Application Ref:	3/2021/0529	 Ribble Valley Borough Council www.ribblevalley.gov.uk
Date Inspected:	15/3/2021	
Officer:	BT	
DELEGATED ITEM FILE REPORT:		NON MATERIAL AMENDMENT

Application Description:	Non-Material amendment of planning application 3/2021/0165. Proposed PVC cladding to the exterior of the dormer instead of concrete tiles.
Site Address/Location:	23 Mayfair Crescent, Wilpshire, Blackburn. BB1 9PY

FRONT ELEVATION ( SOUTH ) PROPOSED

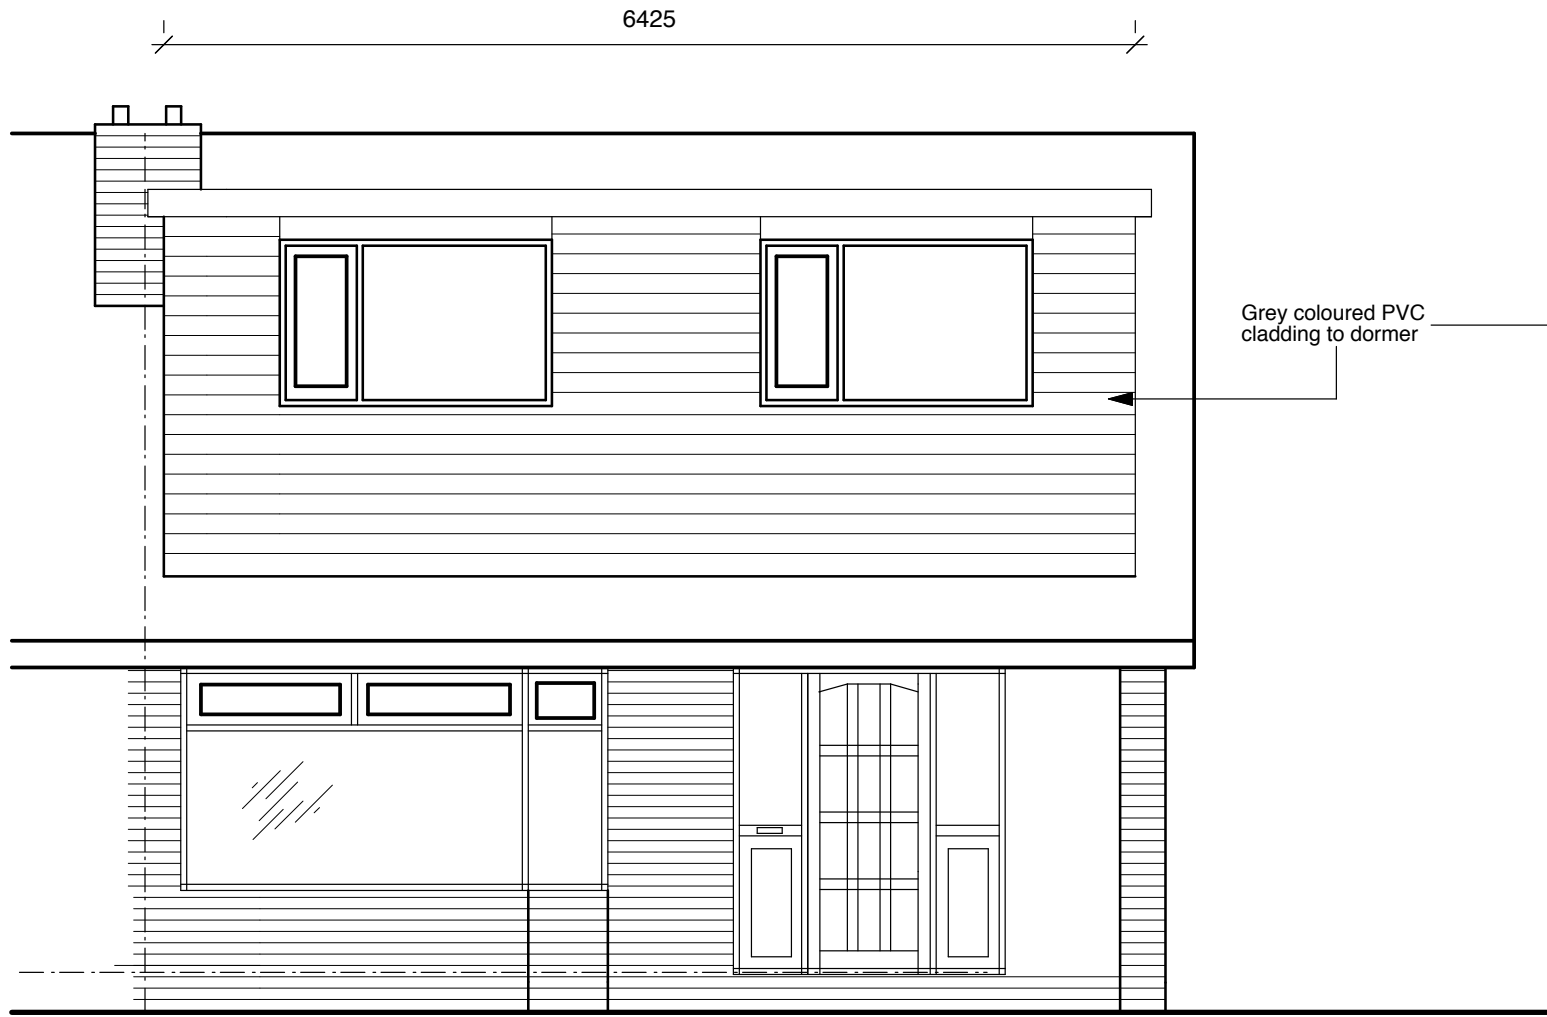
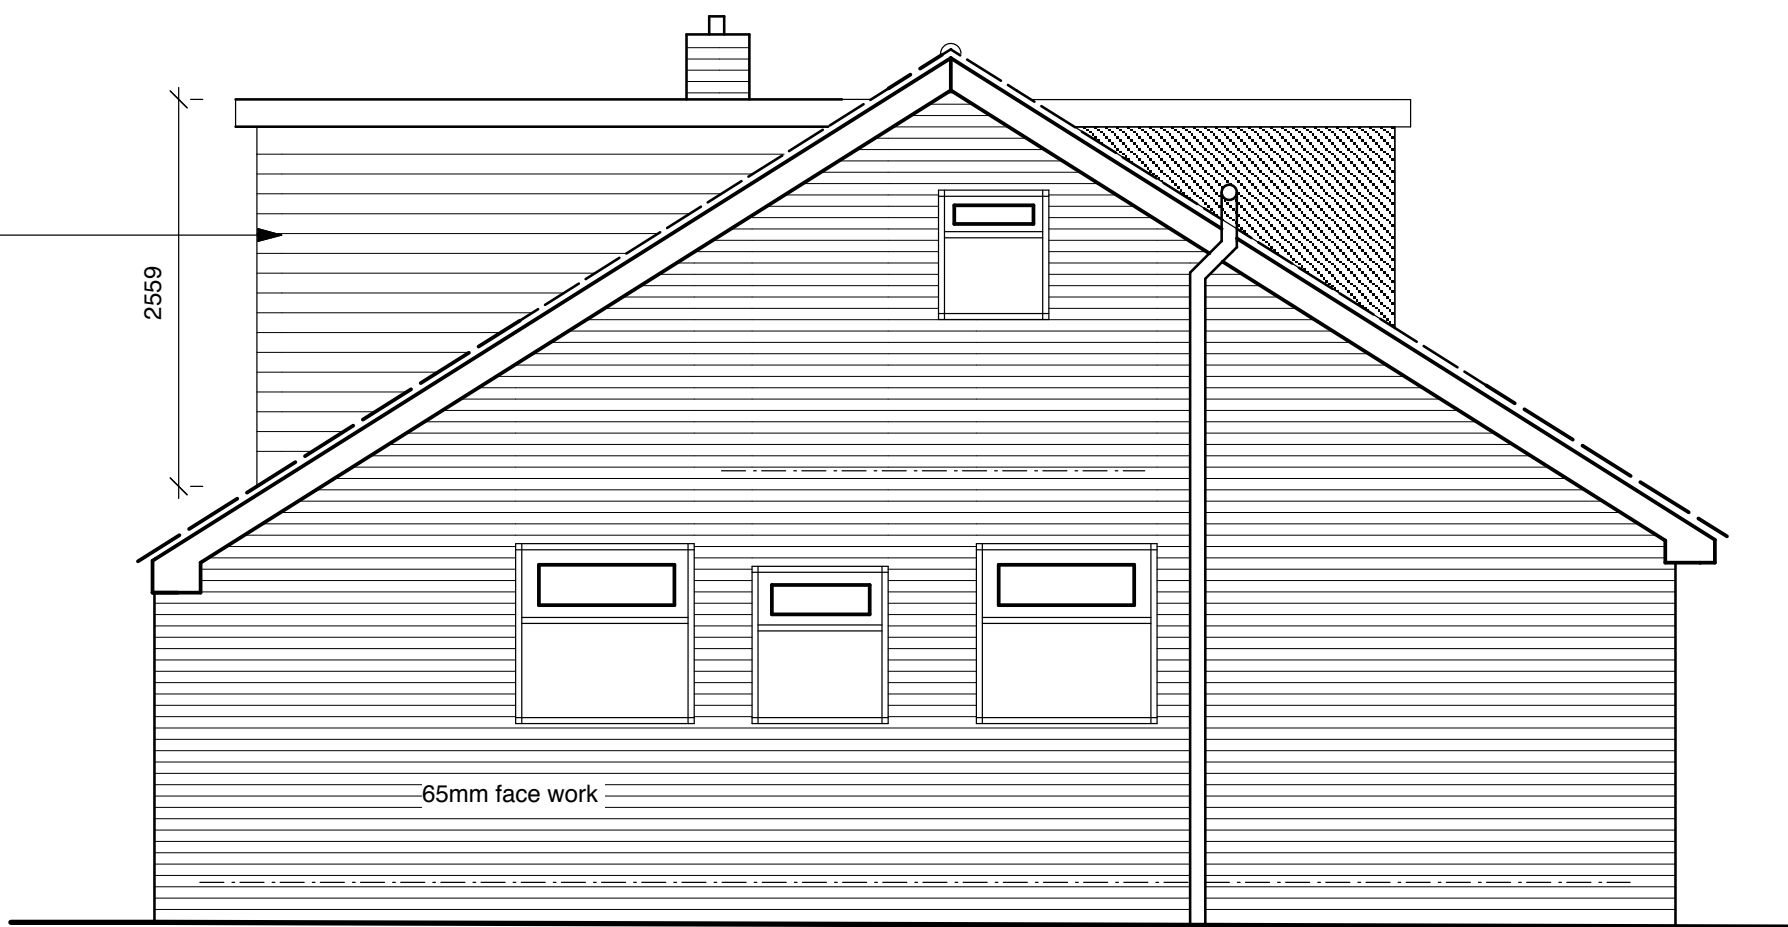
The applicant wishes to change the external materials of the originally approved dormer extension from concrete hanging tiles to grey PVC cladding in order to improve the aesthetic of the approved front dormer.

Accordingly, it is not considered that the incorporation of grey PVC cladding to the external elevations of the approved front dormer would fundamentally alter the external appearance of the original property or lead to any harmful impact upon the visual character of the existing street scene.

The non-material amendment should be granted.
